Our Ref: BR/176/18/PL
Your Ref:

Town & Country Planning Act 1990 (as amended)
Town and Country Planning (Development Management Procedure) (England) Order 2015
Application for Planning Permission

Development Creation of balcony at 2nd floor level (east). Replace existing balcony balustrades at first floor level (east) - This application affects the character & appearance of The Steyne, Bognor Conservation Area

Location 2 & 3 Langford House 7 The Steyne Bognor Regis

Drawing
Location and block plans

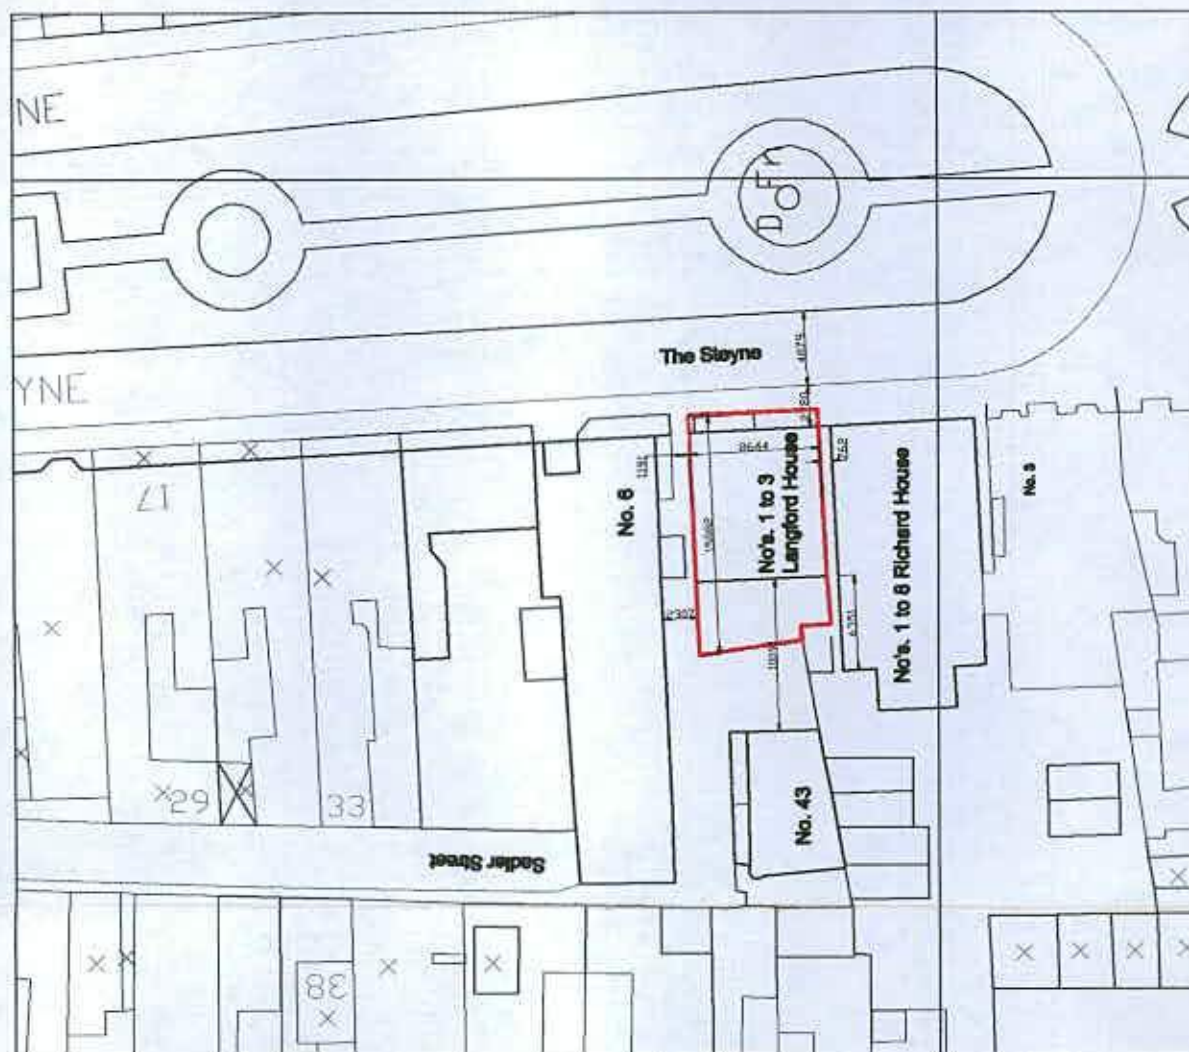
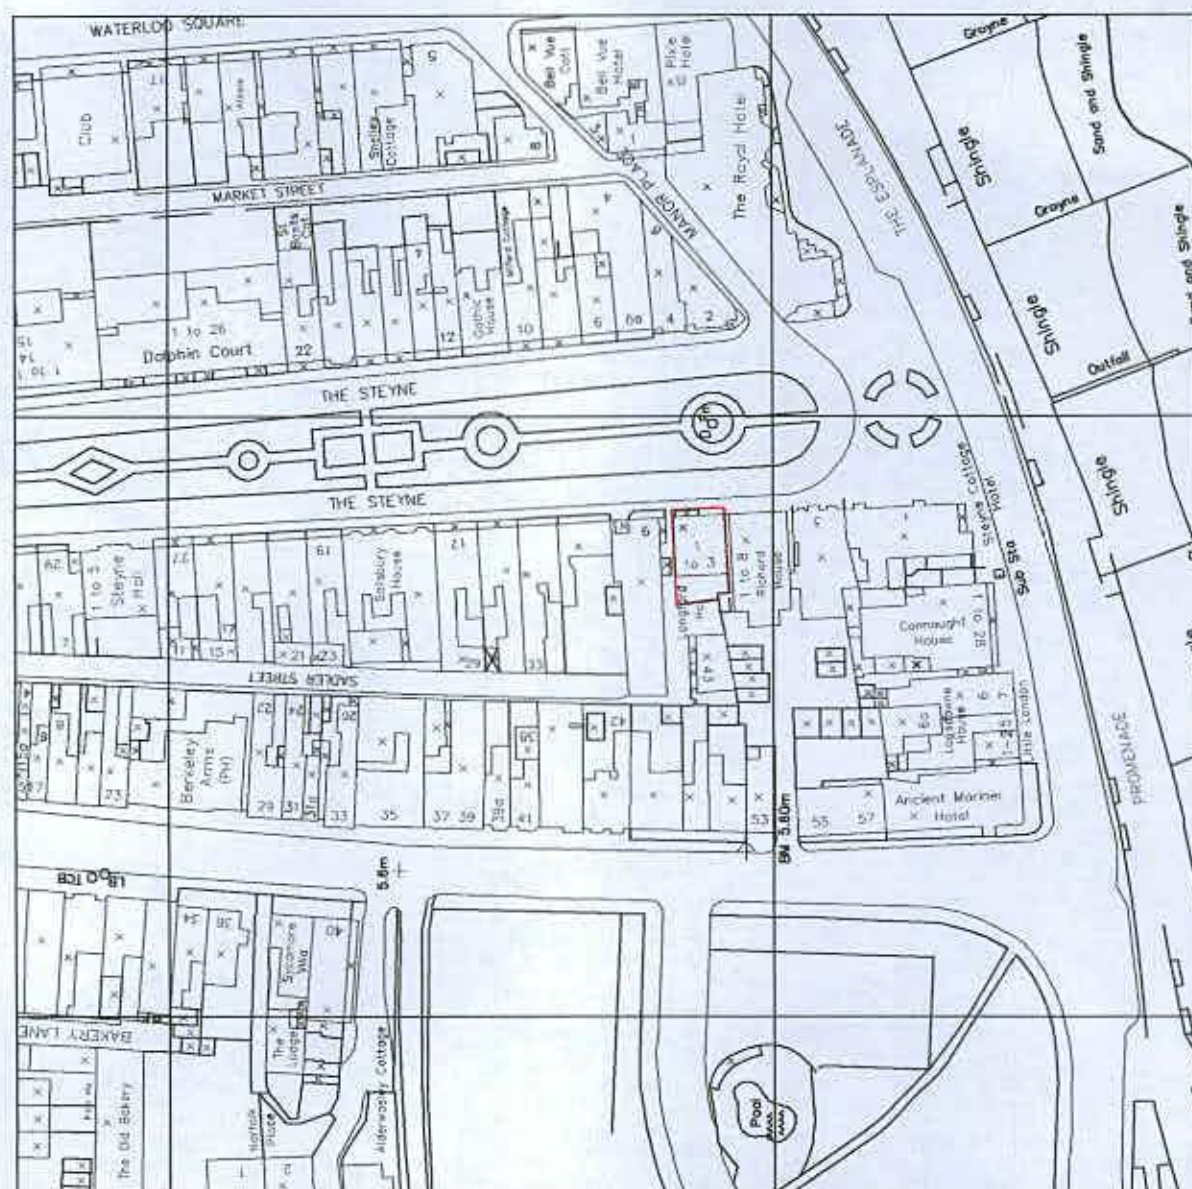
Please highlight on the block plan the position of the proposed works
